**Your ref: TR010056**

**Mr and Mrs R de Lisle Wells – land NW of Shab Hill Junction – Plots 1219/1**

**Planning Act 2008 – Section 88 and The Infrastructure Planning (Examination Procedure) Rules 2010 – Rules 4, 6 and 9**

Drawing Title: **FIGURE 13.19 SCHEME HIGHWAY DRAINAGE - PLAN**

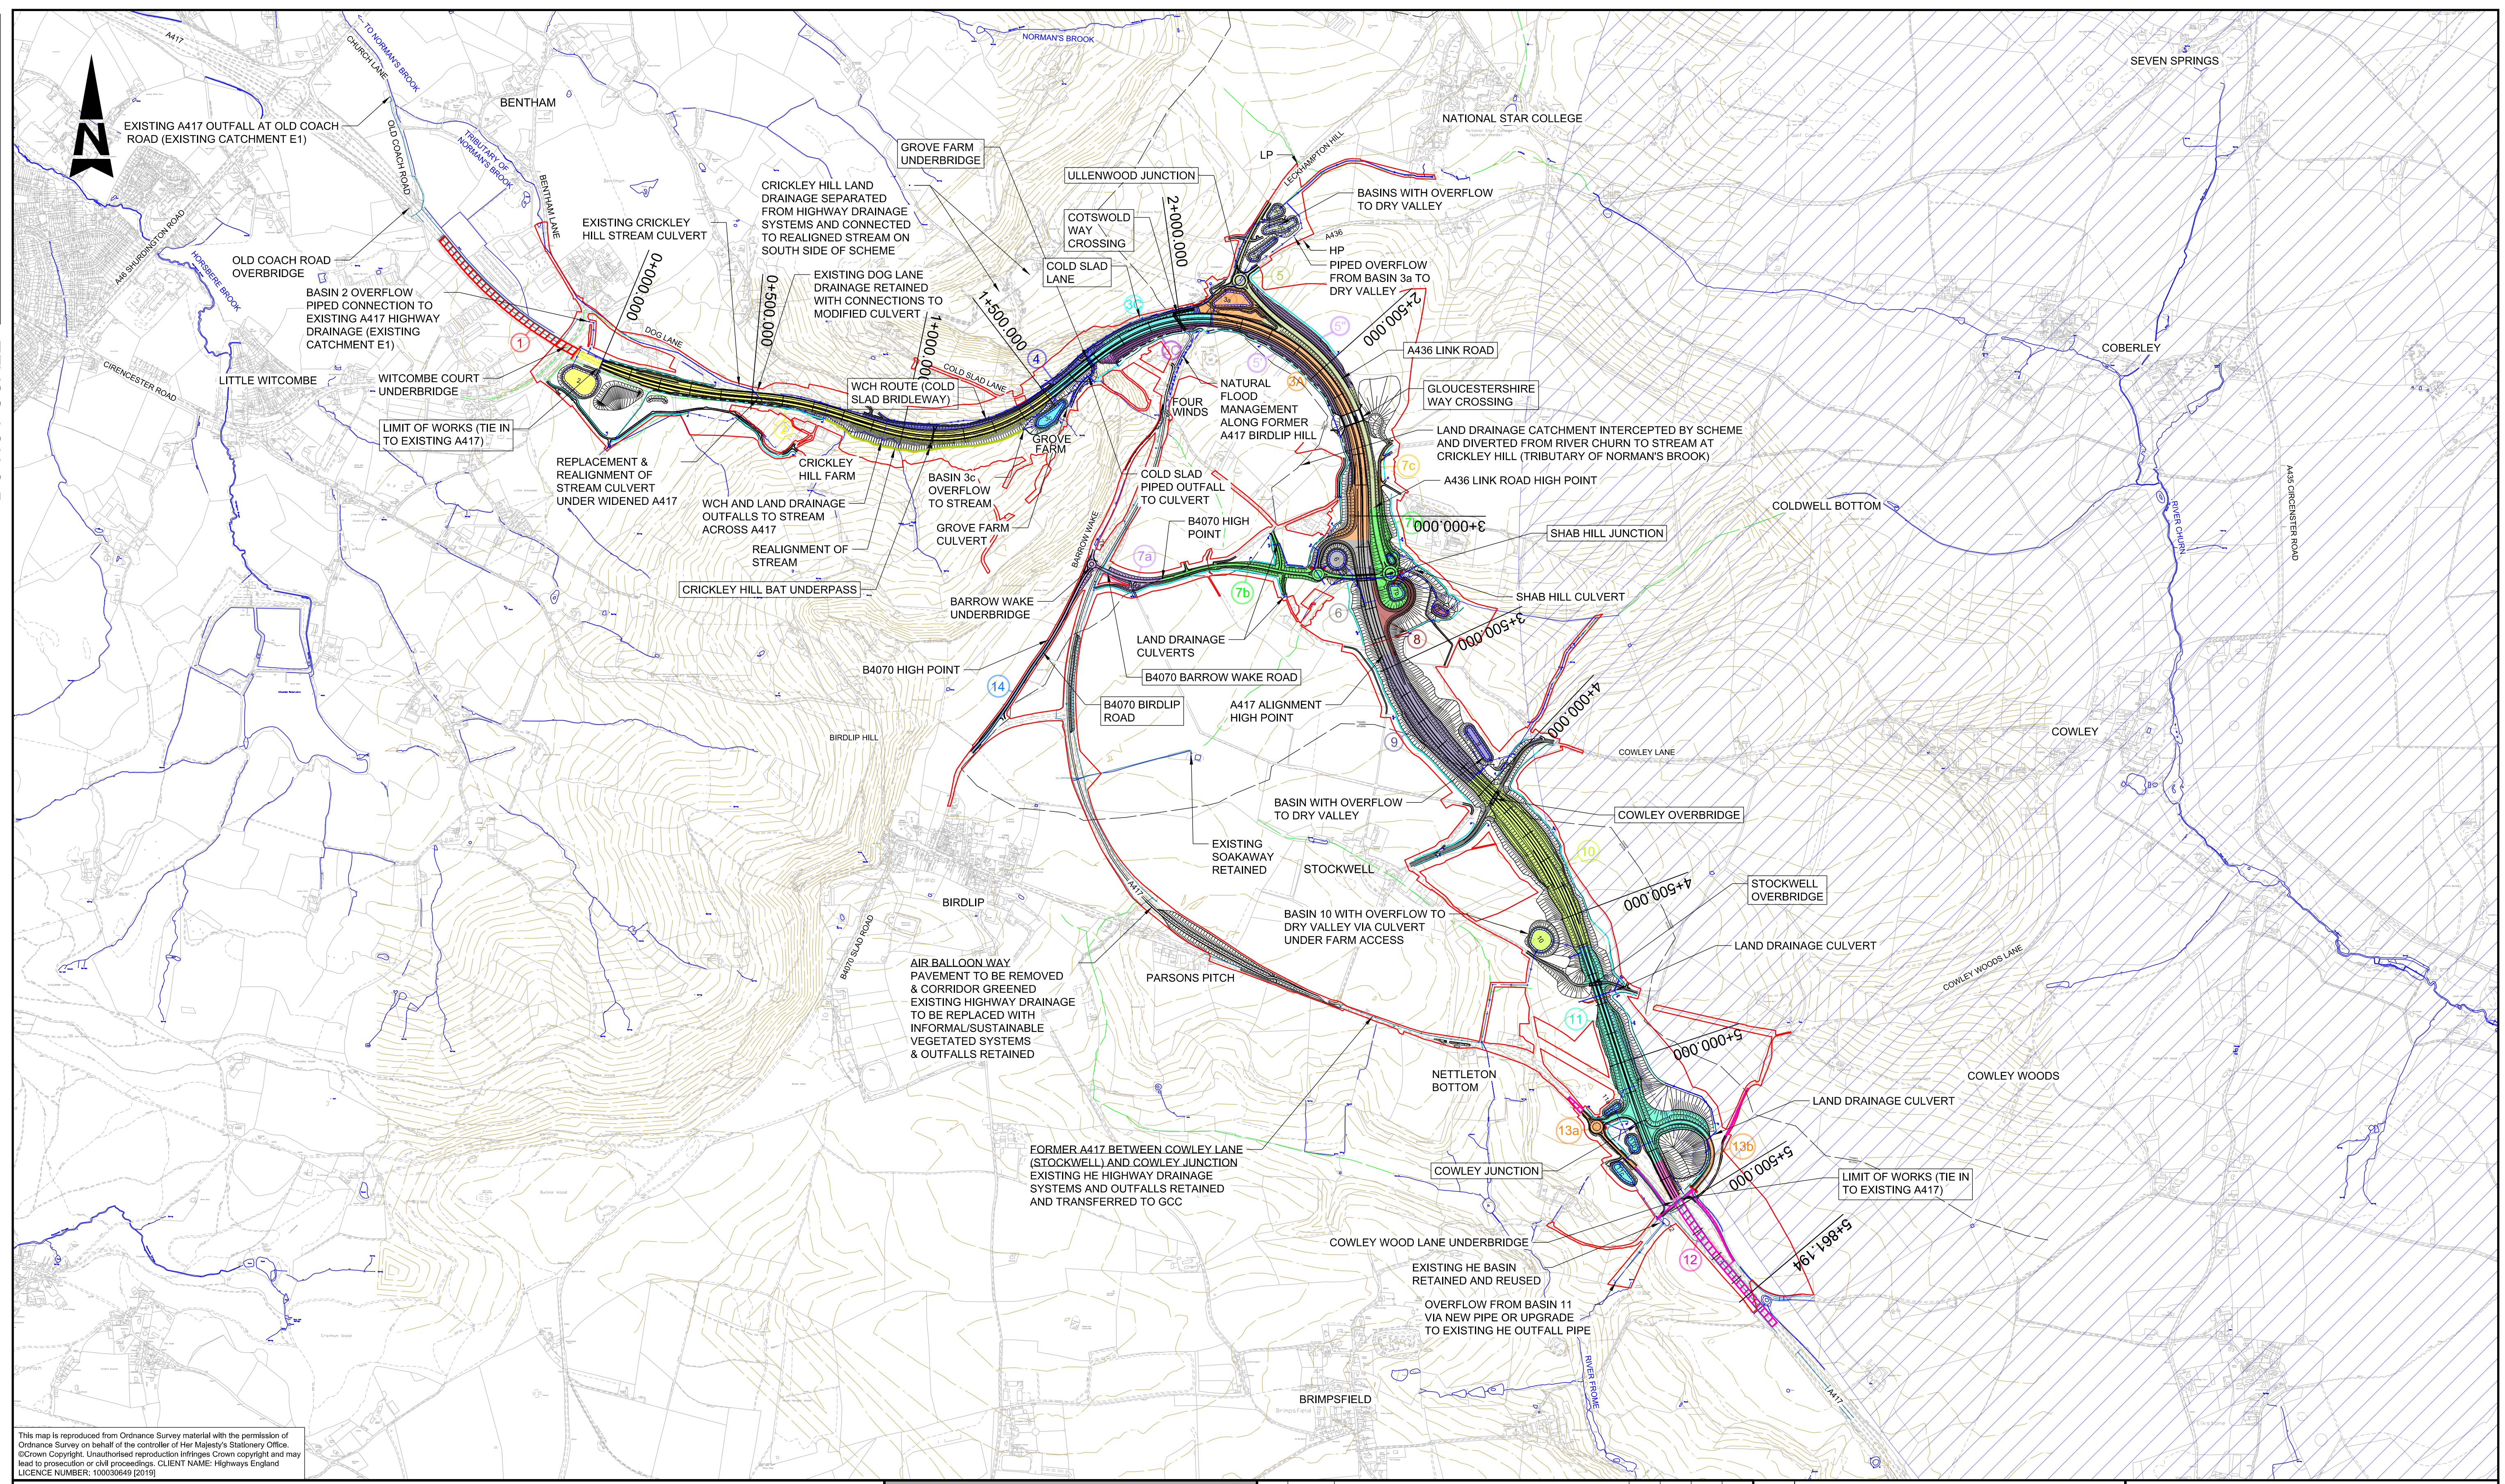
Mr & Mrs de Lisle Wells note the intention to install a drainage solution in the permanent land take. This must be a covered drain to prevent litter and other items causing blockages.
